Our ref: S4.55 Modification - 2 Murray Rose Avenue

S4.55 - LANDSCAPE MODIFICATION CHANGES

Please see below points outlining the changes to the through Ground Floor and Roof Plans shown on RPS Drawing No: **L1.04 [04] Ground Floor Plan L1.08[F] Roof Plan L3.04[04] Substation Plan**

## PLANTING ROOF

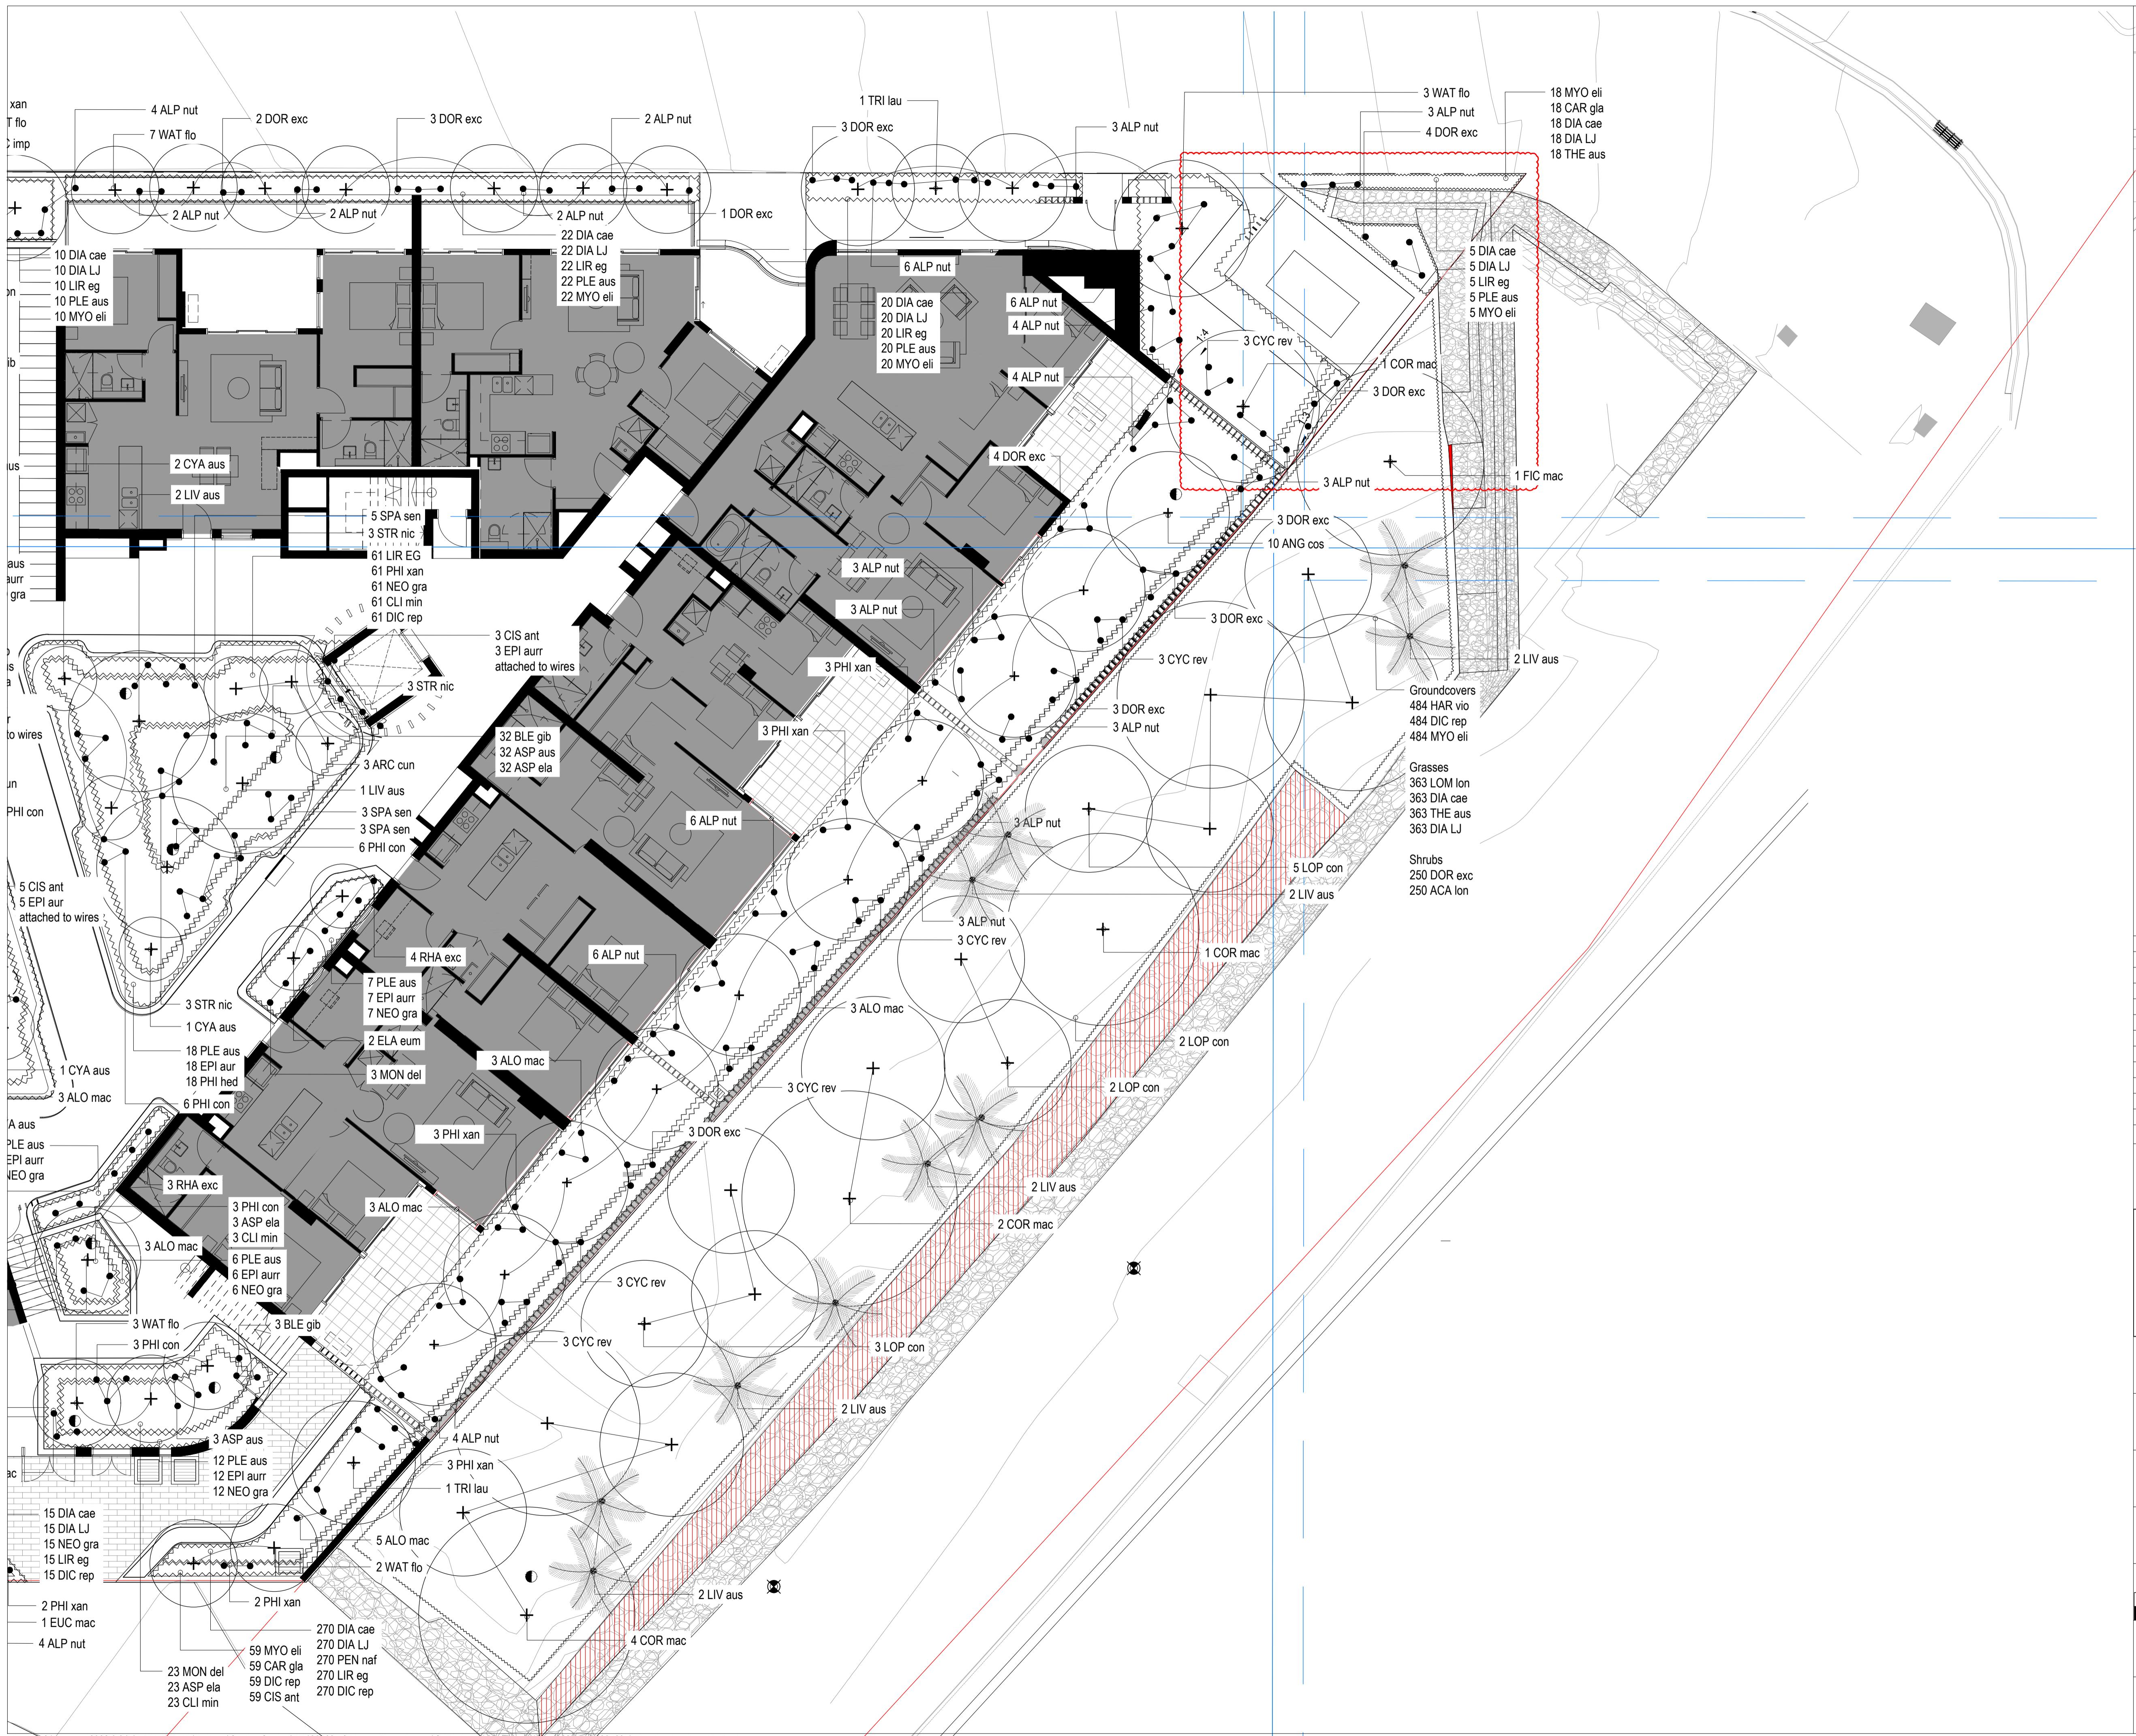
- **Roof Planter Detailed Revised to Large GRC Tubs**
- **Substation on Ground Floor revised**
- **Planting improved around Substation**
- **Increased native plant species to Bennelong Parkway**
- **Reduction in Gabion Wall removal**
